SUBJECT: RIO GRANDE HOUSING
2334 Rio Grande Blvd NW
Site Plan for Building Permit
Project 1009204

Submitted herewith in support of final signoff by DRB is one copy of the Site Plan for Building Permit, revised to address EPC conditions of approval, as outlined in the Official Notification of Decision, dated May, 10, 2012.

A6 EAST ELEVATION (VIEW FROM COURTYARD) WEST ELEVATION (VIEW FROM PARKING)
1/8" = 1'-0"

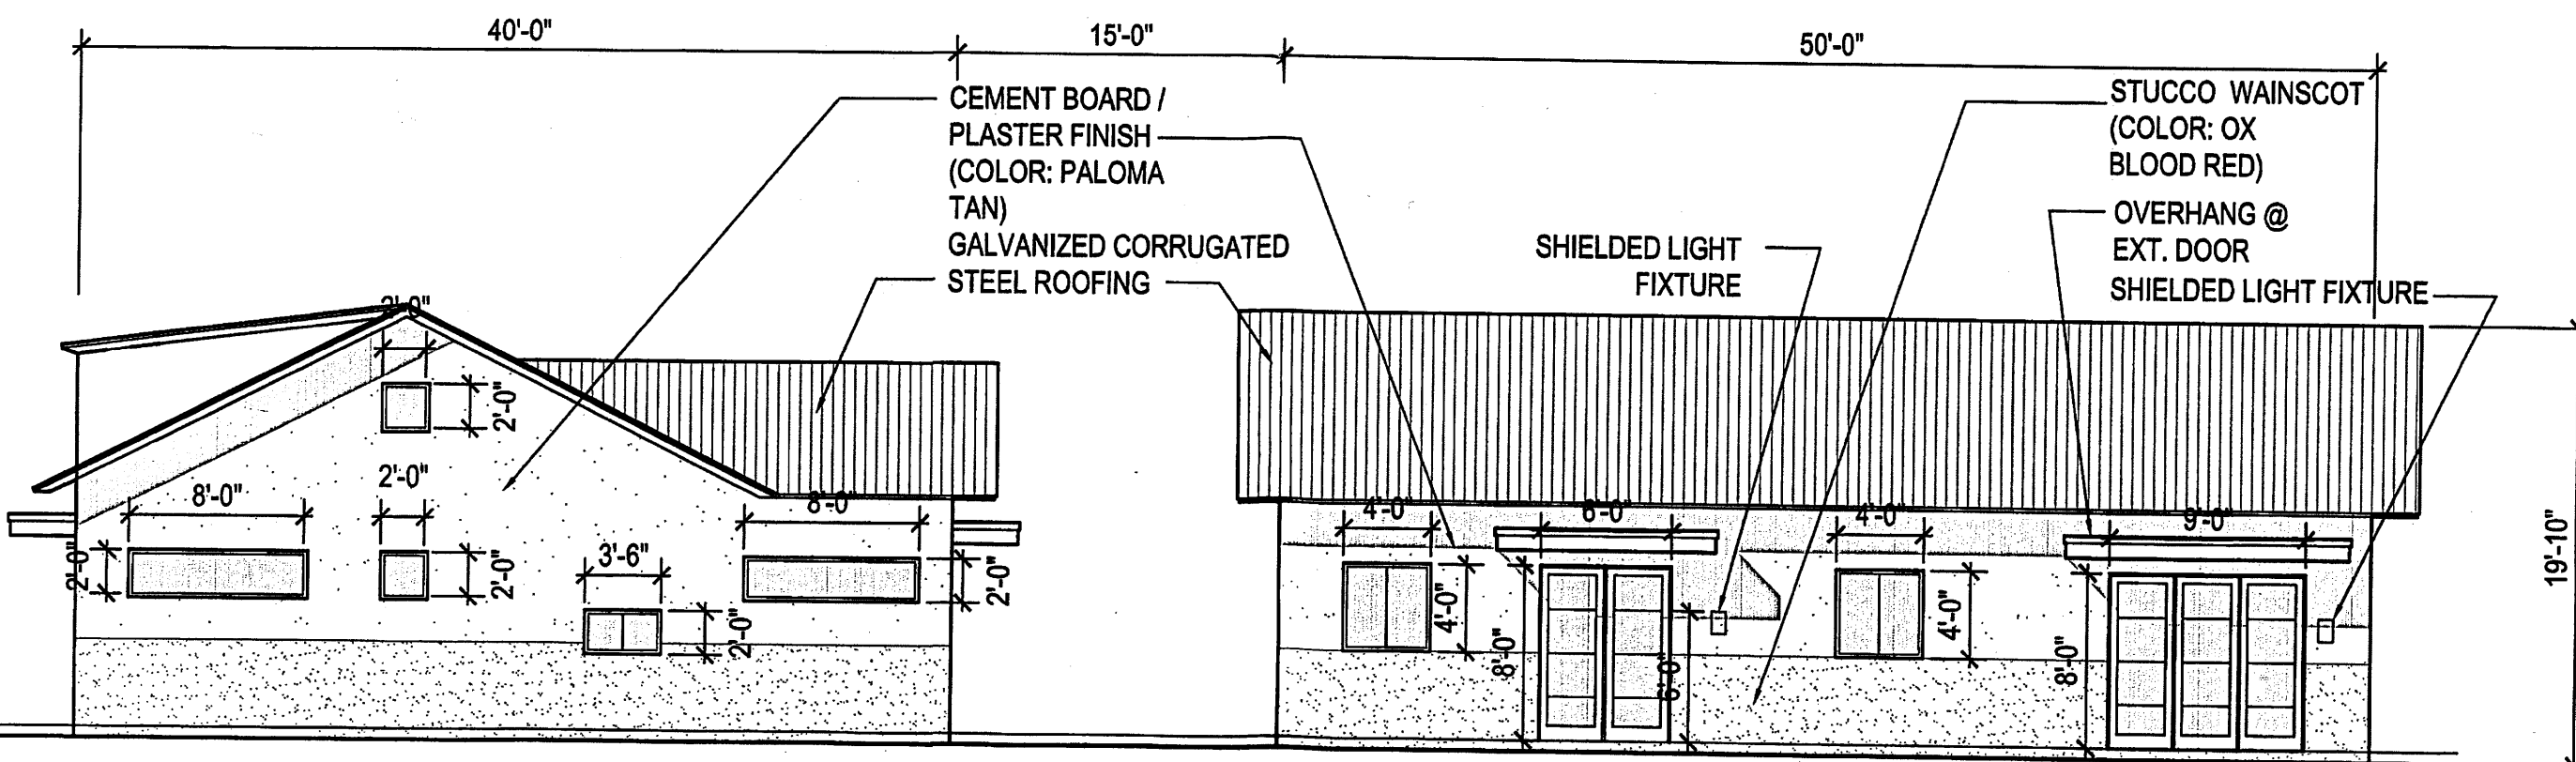
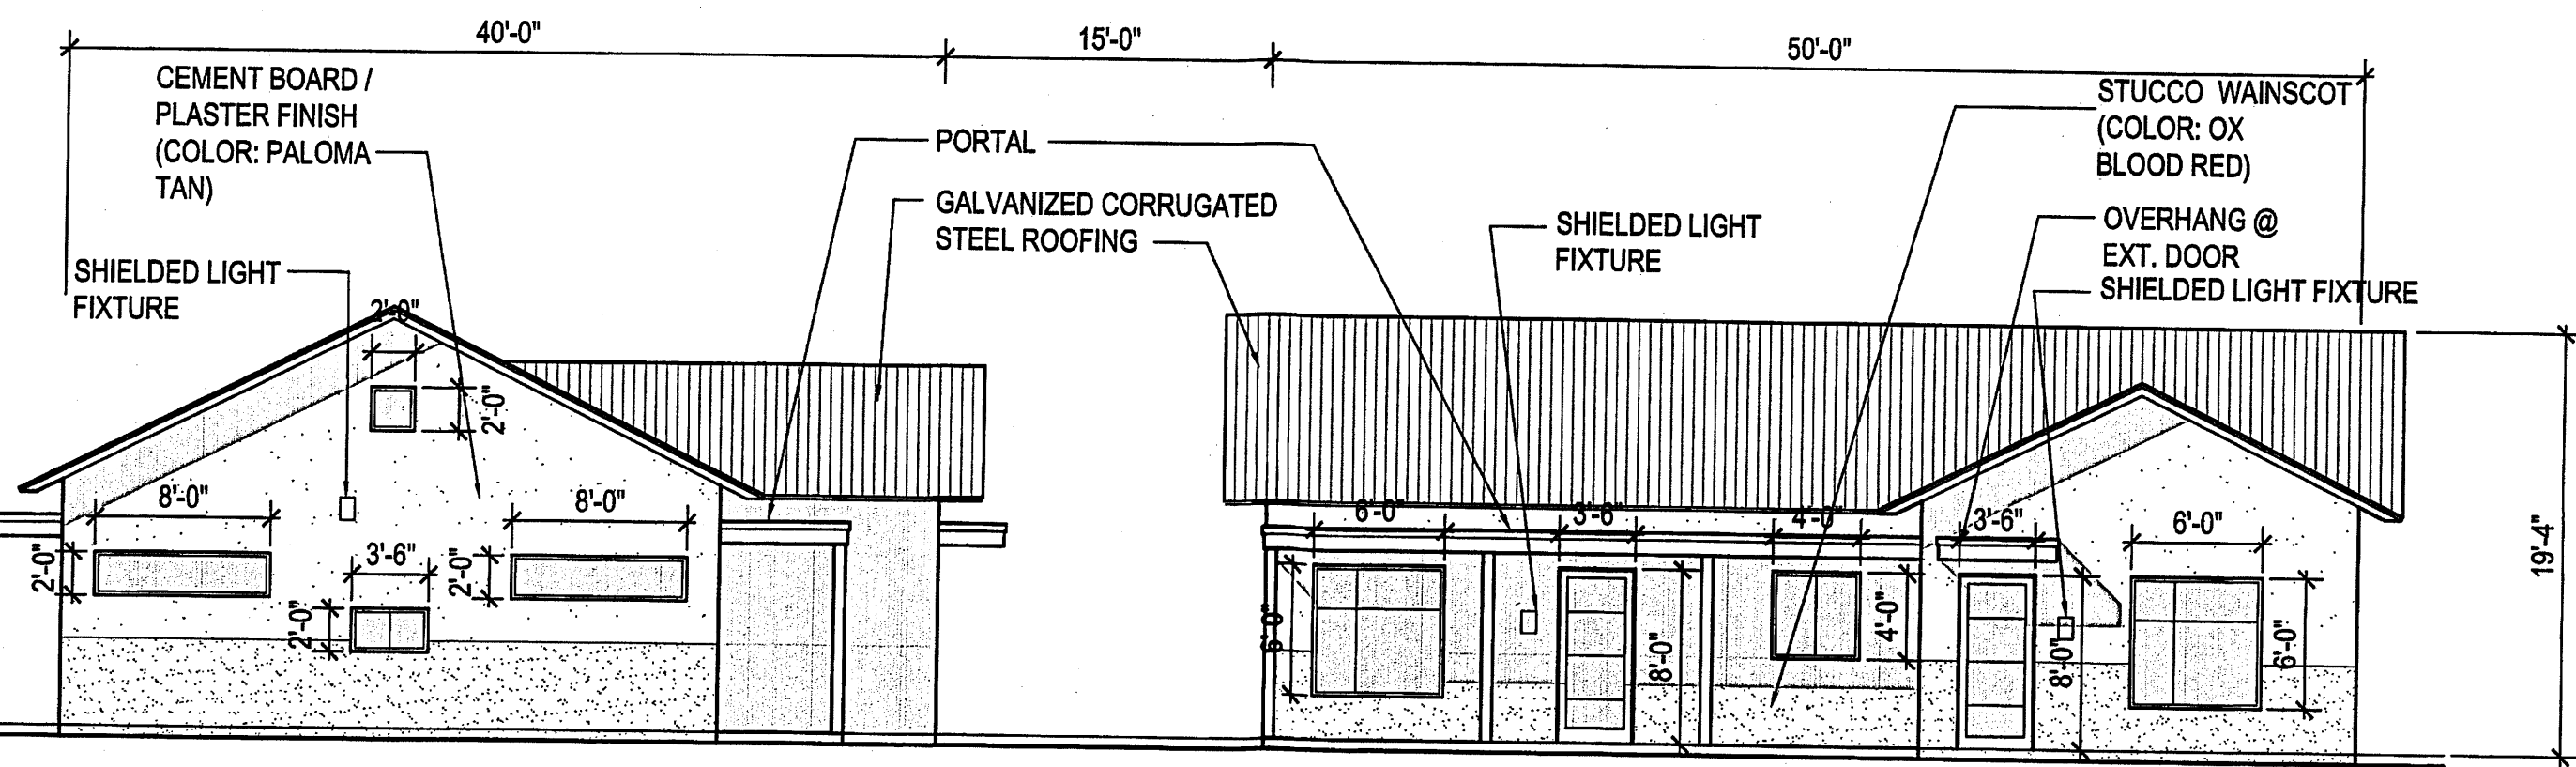
11. The landscaping shown on the Landscaping Plan matches the Landscaping Legend.
 12. The maximum building height of 24 feet to the top of the pitch is noted on the building elevations.
